Sydney Grammar School Weigall Sports Complex (SSD-10421)

Response to Request for Information

15 June 2021 | 19049

1.4 Residential Amenity
Proposed
DPIE RTS2 ISSUE 2(A)(B)

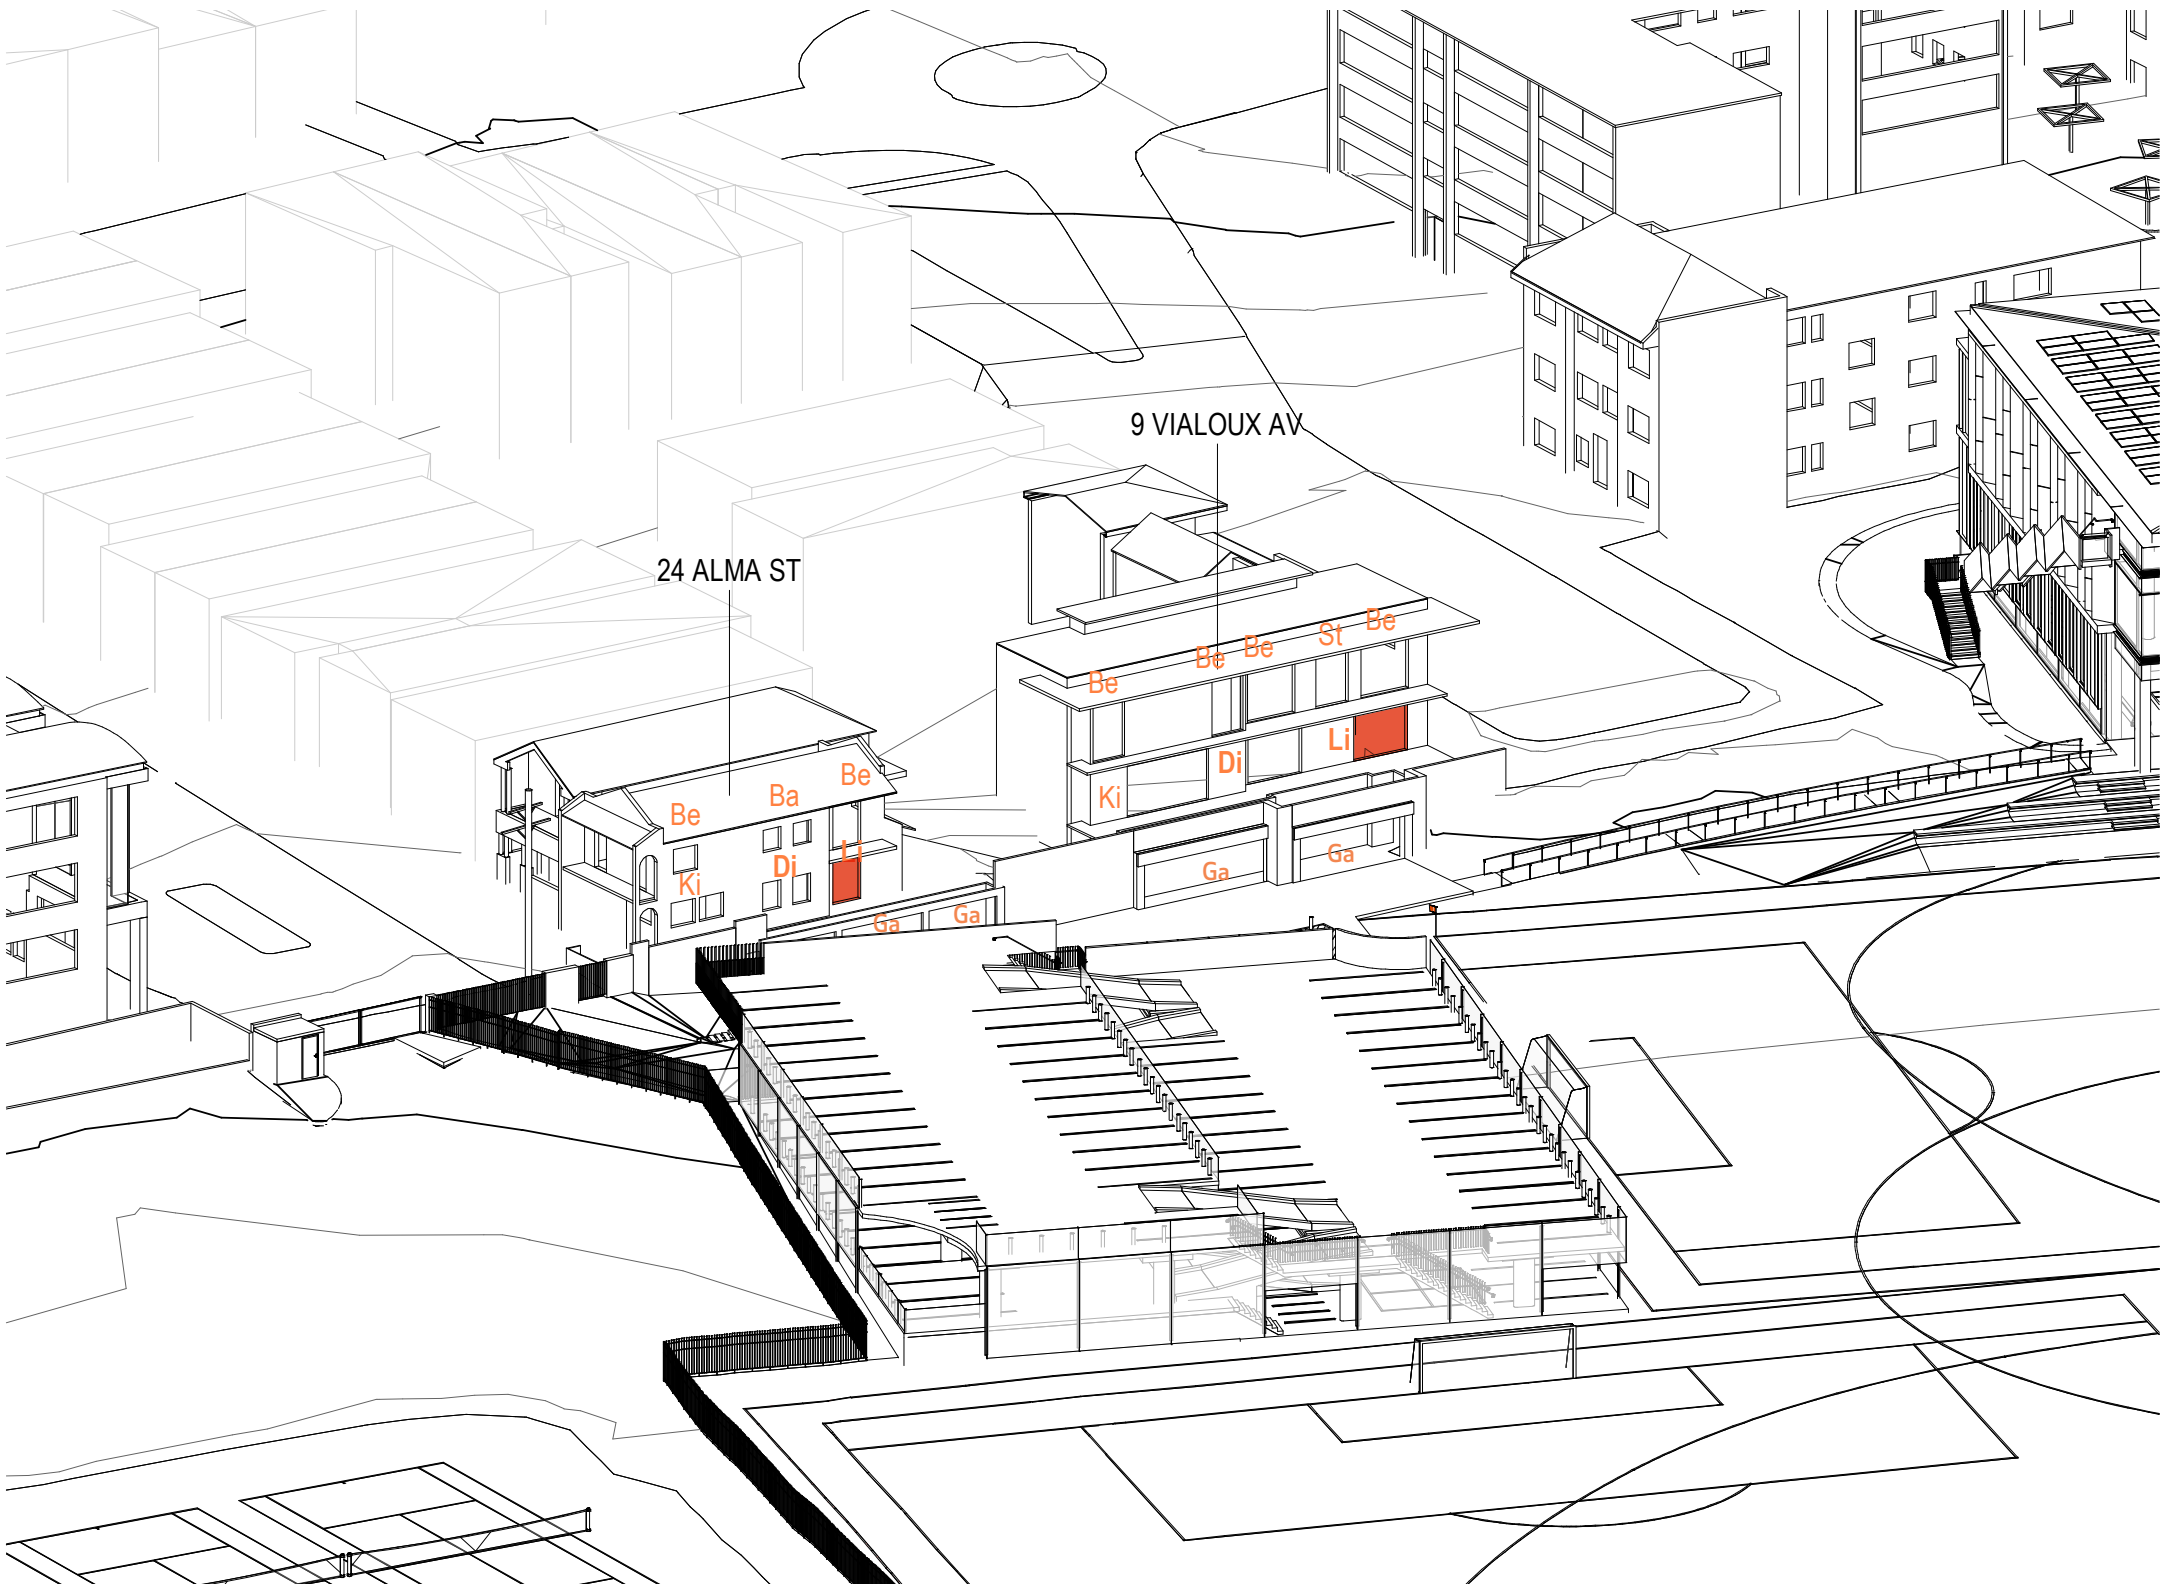
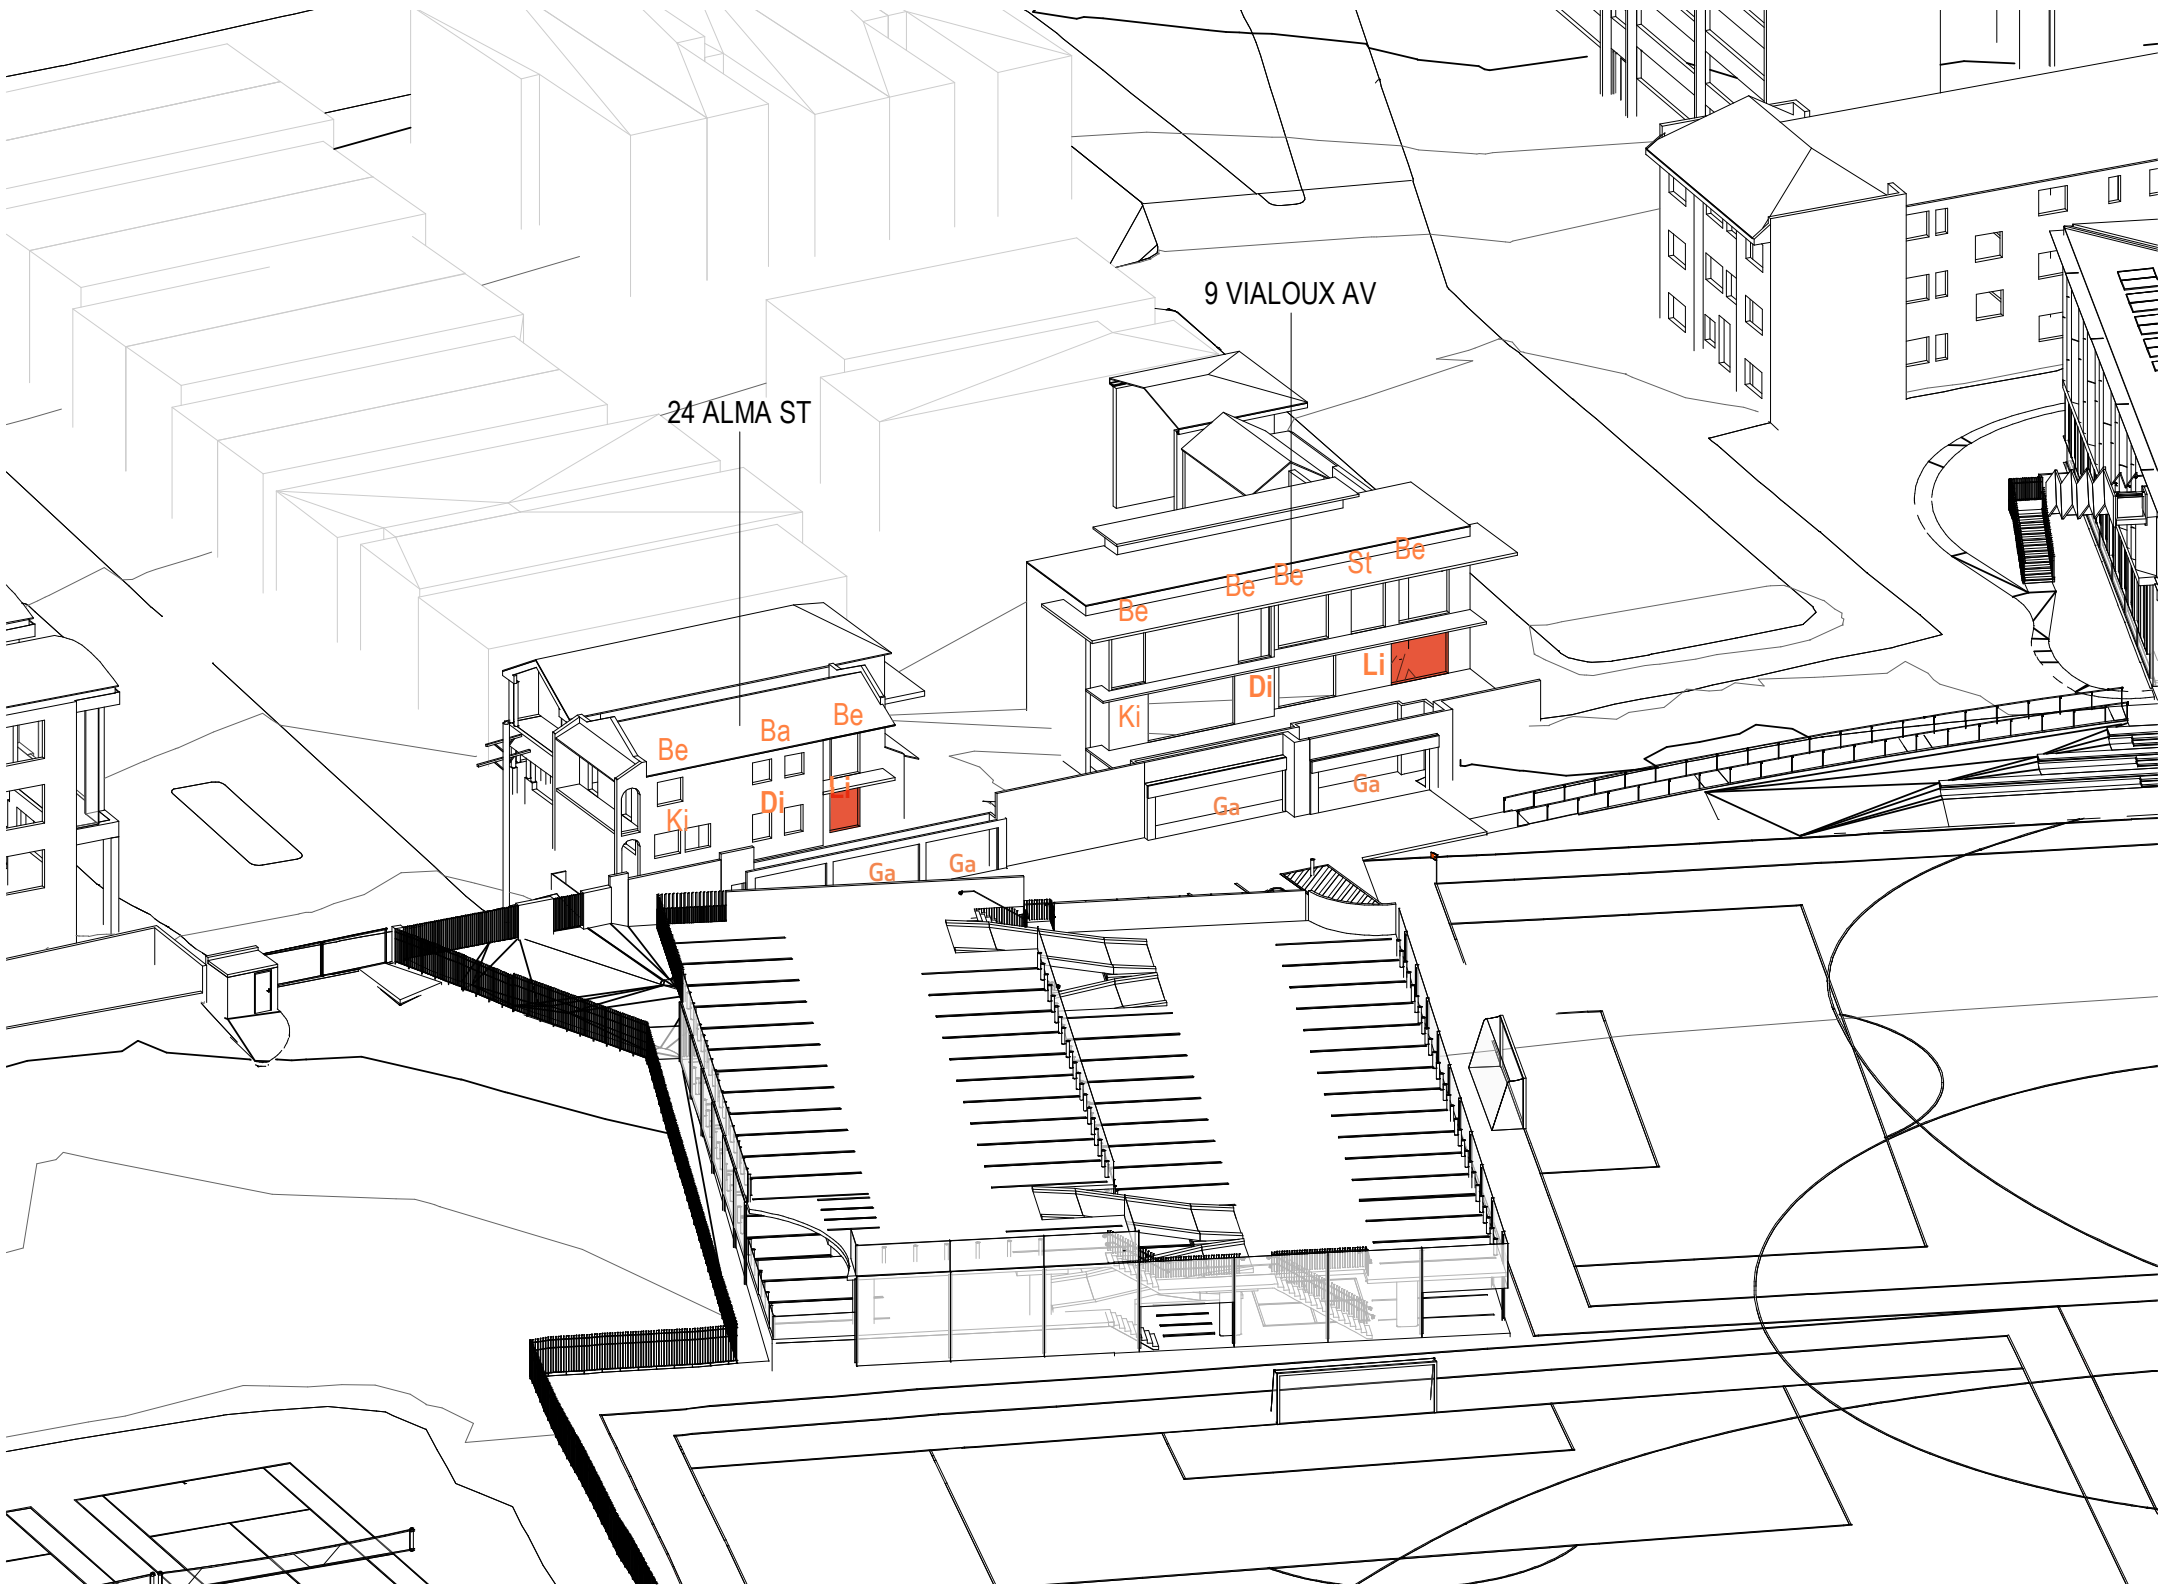
- a) The nature/use of the rooms with windows facing Building 2 and the associated impacts.*
- b) Impacts of Building 2 on solar access, view and outlook of the abovementioned properties.*
- c) Impacts of light-spill from cars (due to headlights) on the Building 2 roof top car park.*

Solar access: The sun's eye studies by AJ+C (**RFI Appendix B**) show that from 9.00am to sometime after 2.30pm in midwinter (at least 5½ hours), the proposal will not reduce solar access to any windows or open spaces at 9 Vialoux Avenue. At 3.00pm only, the ground floor living room will be overshadowed by Building 1. Given the short duration of impact, the shadow impact on 9 Vialoux Avenue is considered to be minimal and reasonable.
